Our ref: STH18/00035
Contact: Emma Pietruska 4253 2609
Your ref: SSD9143

**REQUEST FOR SECRETARY'S ENVIRONMENTAL ASSESSMENT REQUIREMENTS – GOULBURN
MIXED USE DEVELOPMENT DEVELOPMENT – SSD 9143**

Roads and Maritime Services (RMS) refers to your correspondence dated 18 September 2019 regarding the subject development application.

**Existing weekday morning
peak hour traffic flows plus
development traffic
Figure 2**

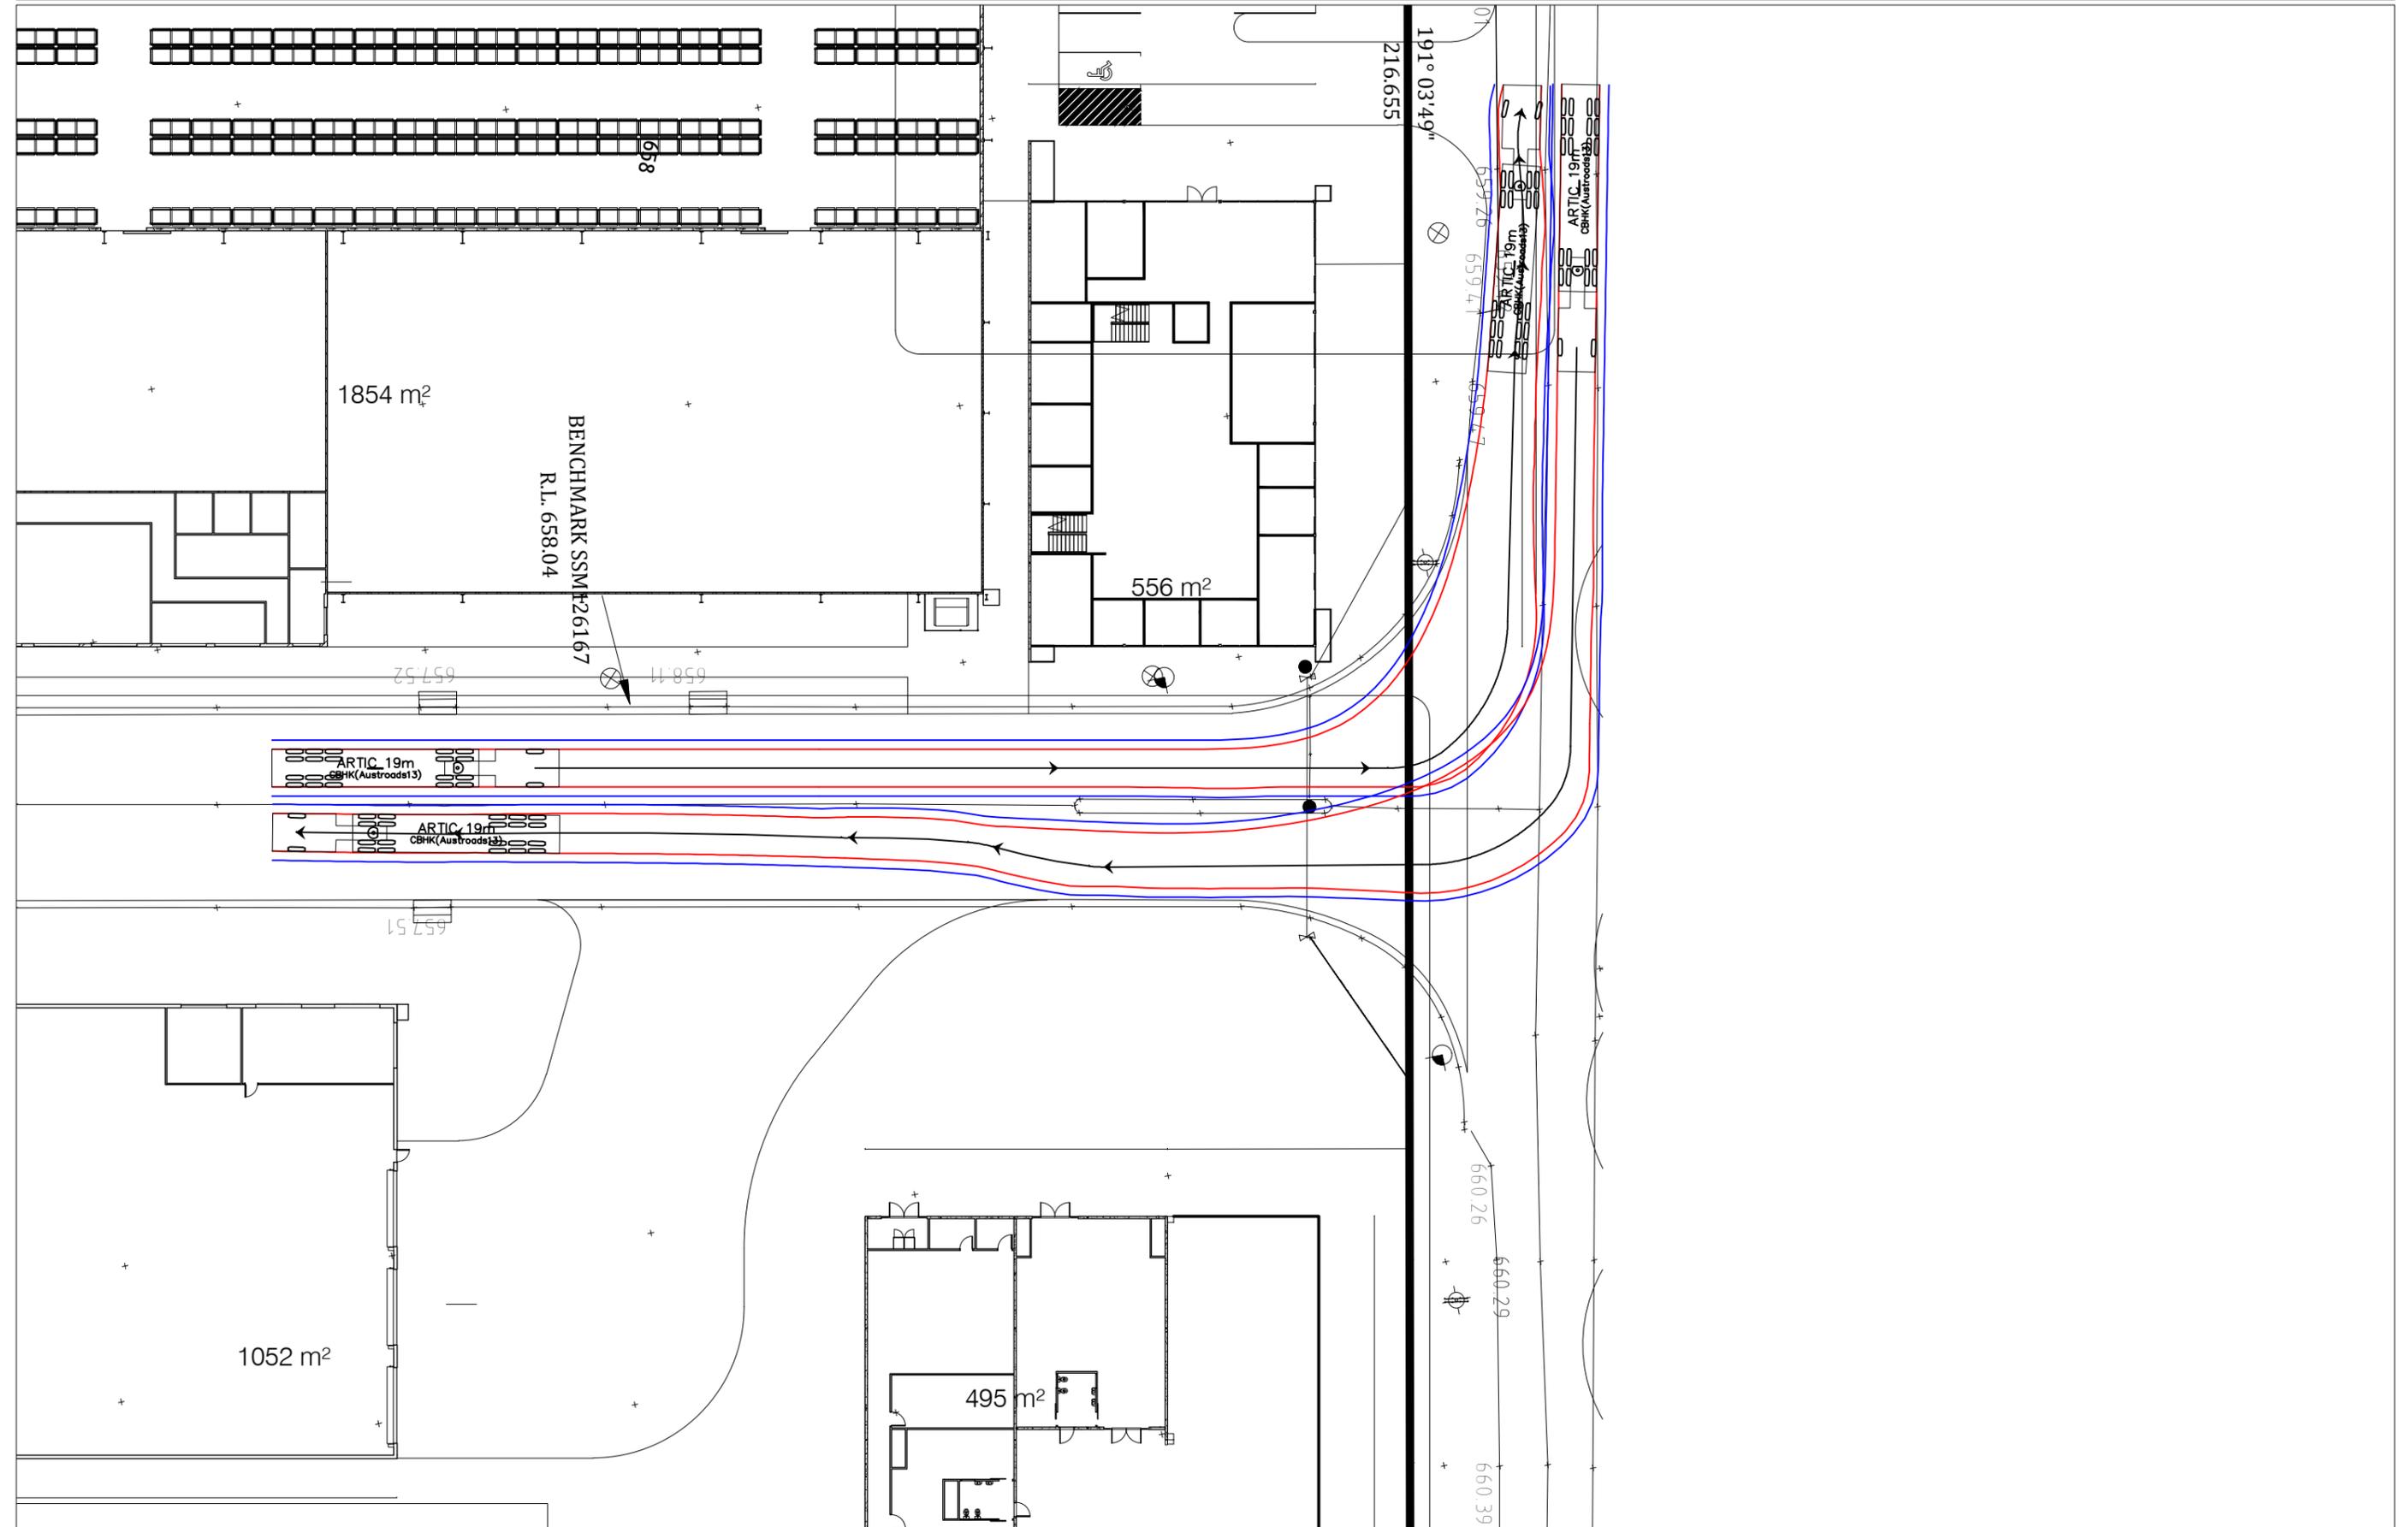
- RMS notes that two-way peak hour traffic flows has been provided, however the dates and times that these traffic flows were collected are not identified. Intersection traffic modelling is required for Common Street and Sydney Road, and Common Street and Sinclair Street.

- The modelling would need to consider peak periods (AM, PM) with and without the development.
 - The modelling would need to consider a base case scenario (to demonstrate calibration) and a future scenario (10 years).

- The base models must be calibrated with on-site observations in the AM and PM peak. This can be done by measuring existing queue lengths and delays.
